## **Application by Vattenfall Wind Power Limited for the Thanet Extension Offshore Wind Farm Development Consent Order**

### **The Examining Authority's second written questions and requests for information (ExQ2)**

**Issued on 10 April 2019**

Land Plan (Onshore)

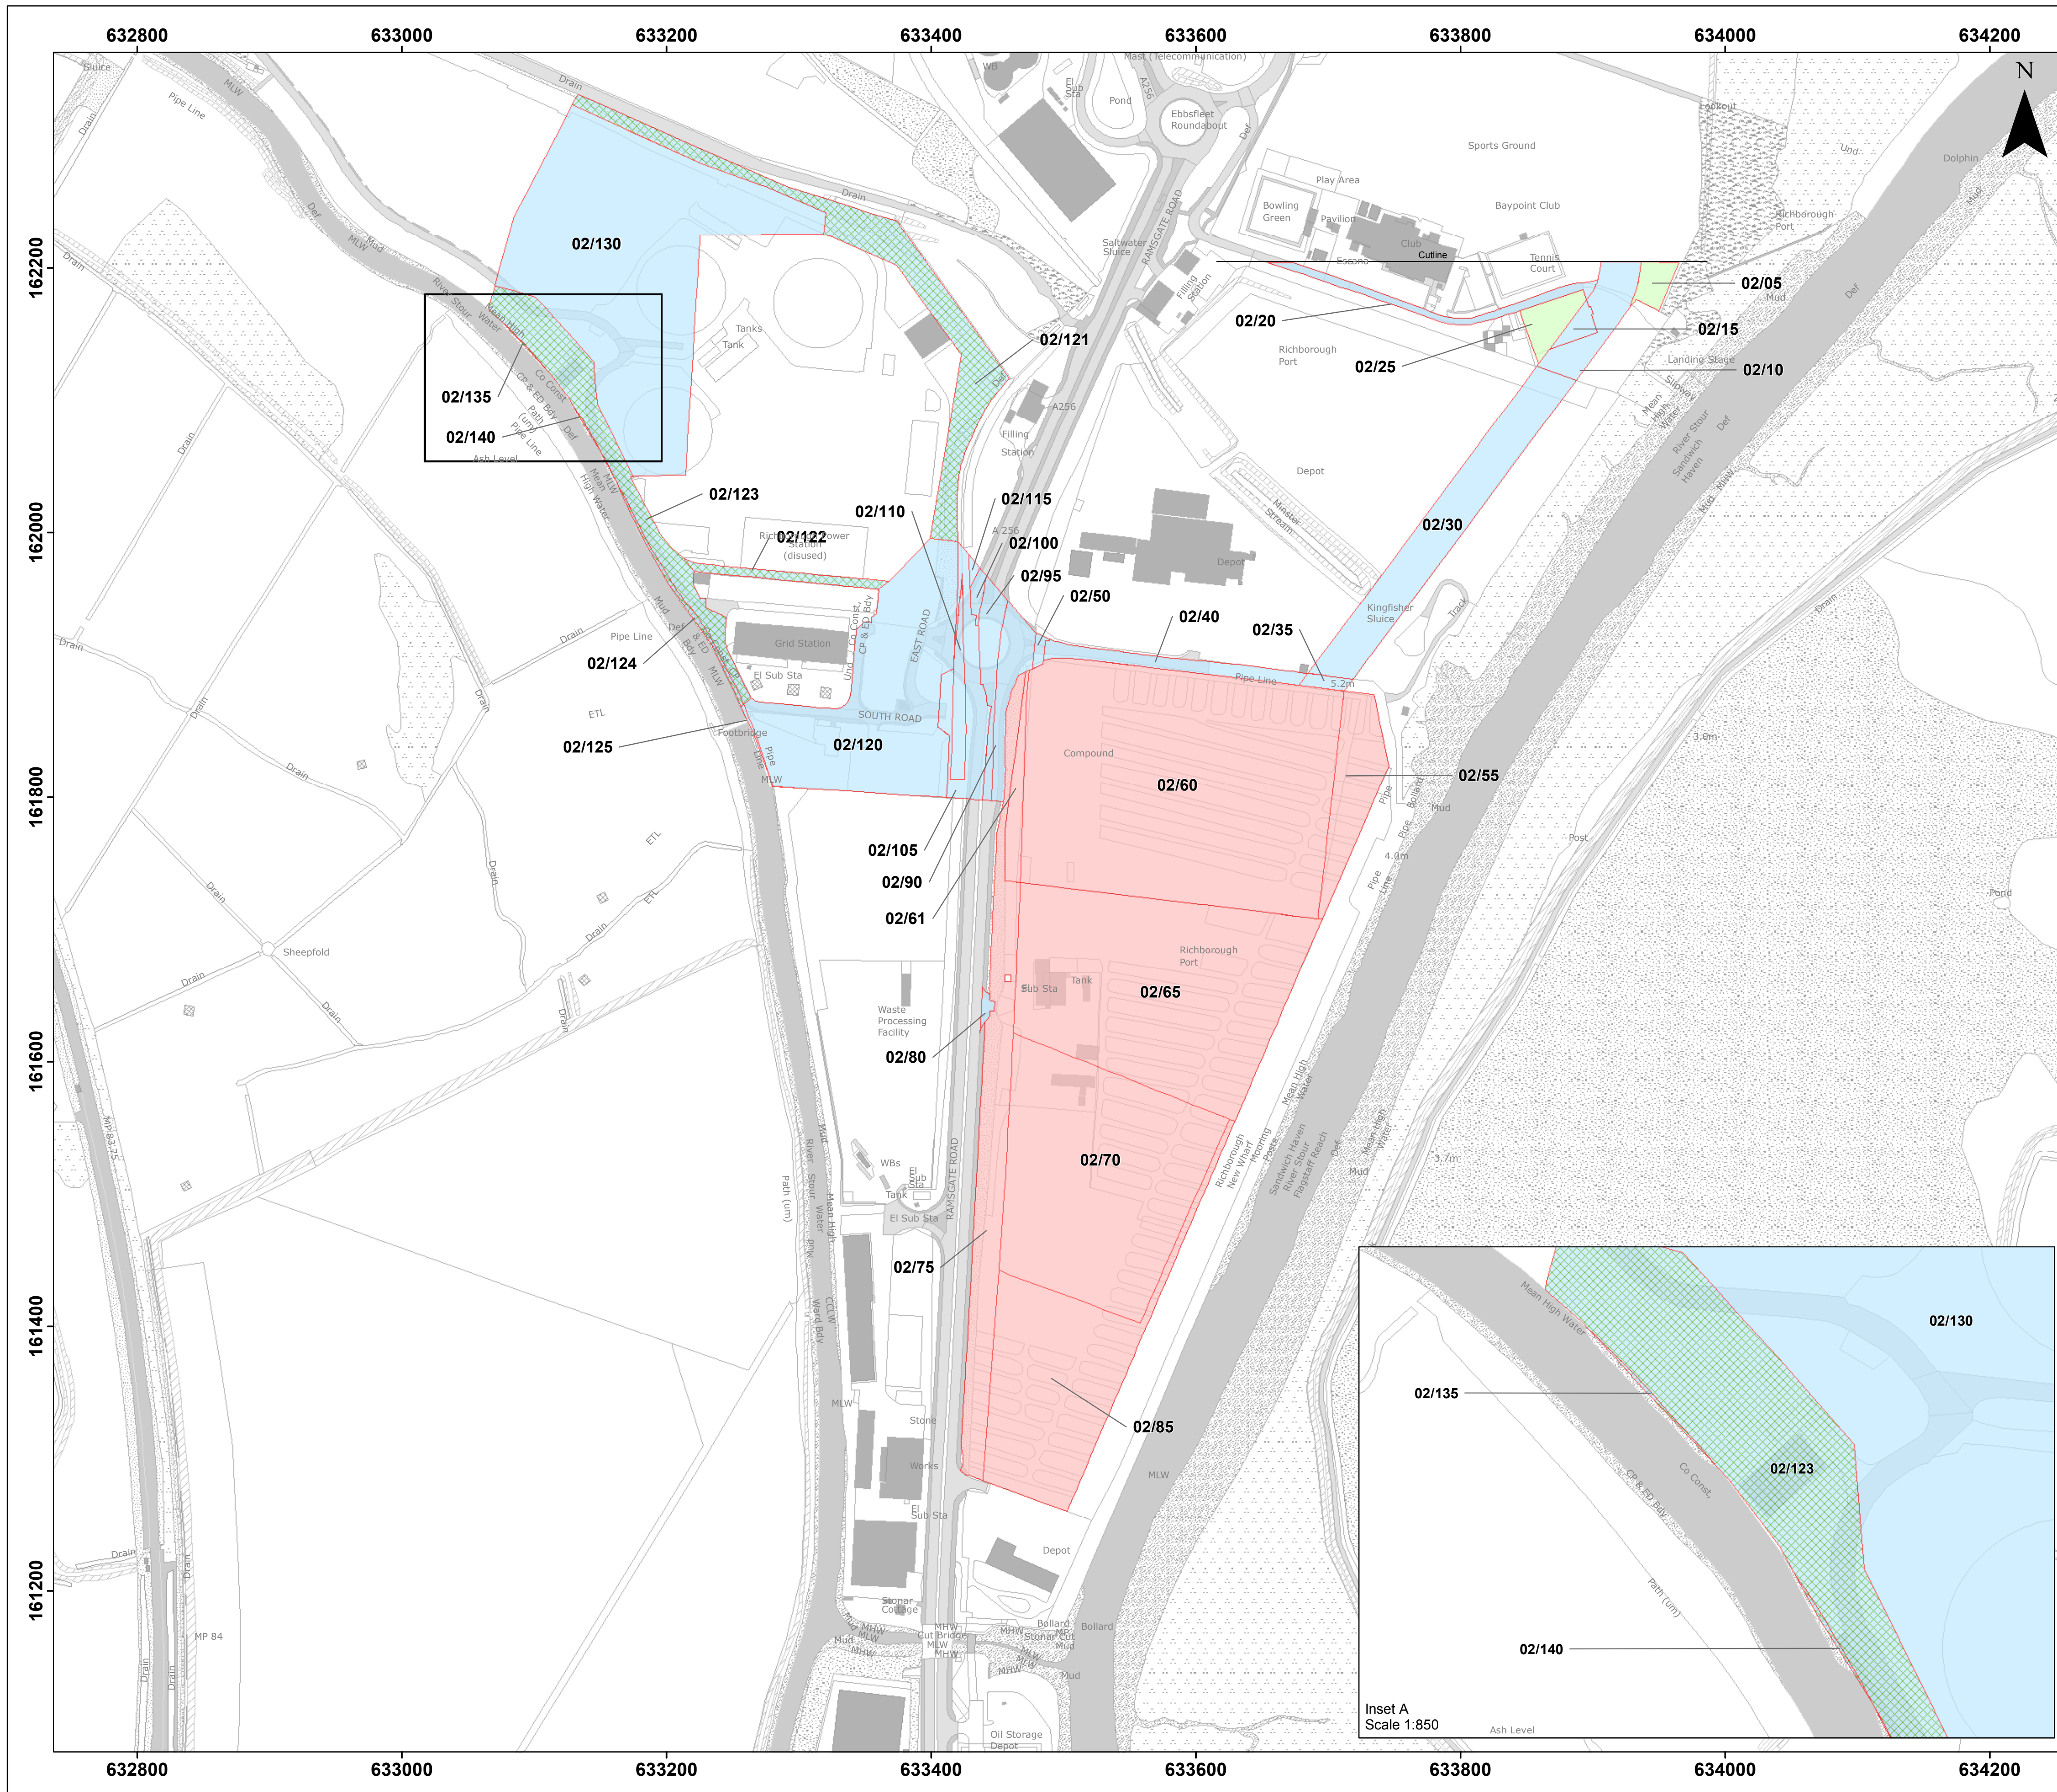
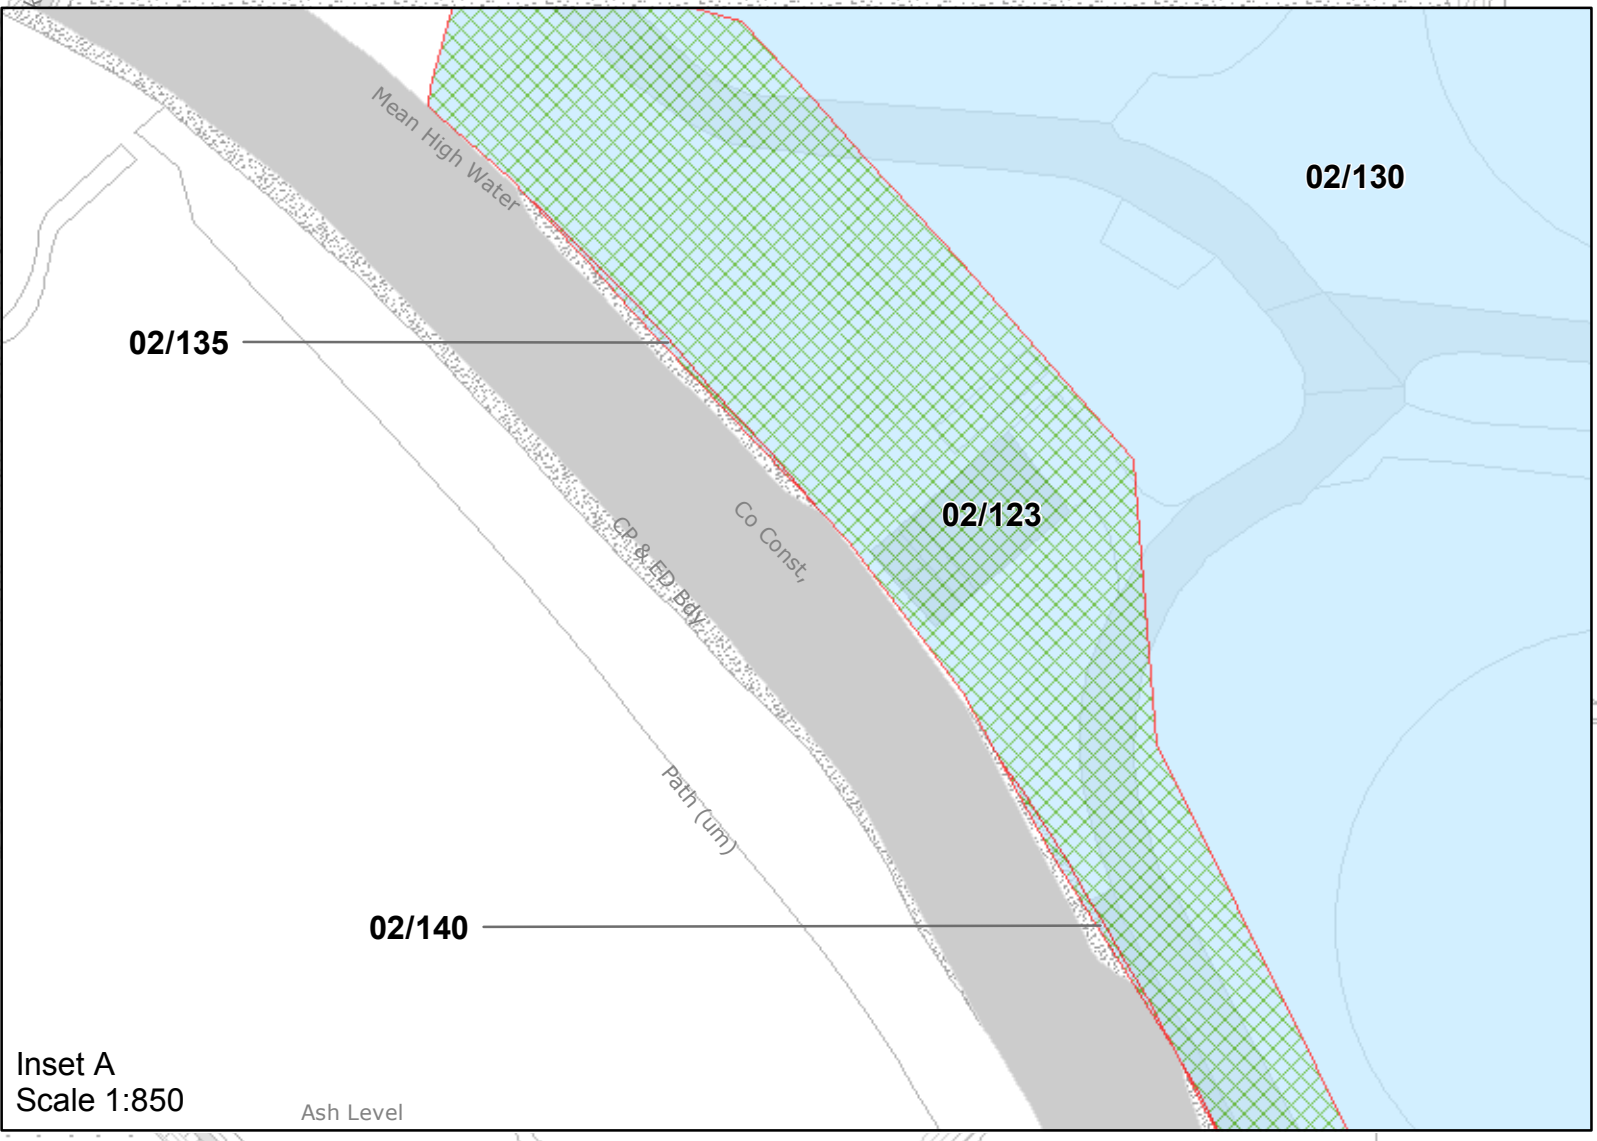
2.3.5.	The Applicant and Ramac	<p><b>Excluded Land: Parcel 02/75</b>                      The Onshore Land Plans identify a small plot of land excluded from the CA request for permanent freehold acquisition on Parcel 02/75.</p> <ul style="list-style-type: none"> <li>a) Can the Applicant please explain the purpose for which this land has been excluded. If the exclusion is in error can the Onshore Land Plans be replaced at Deadline 5.</li> <li>b) Can Ramac please review the Applicant's response to this question at Deadline 5 and if the exclusion is intentional, please identify what effect the exclusion of this land from CA will have on Ramac</li> </ul> <p>{See Land Plans extract identifying the plot}</p>

Extract from Onshore Land Plans Sheet 2 [REP2-011].  
Excluded land highlighted in purple polygon.
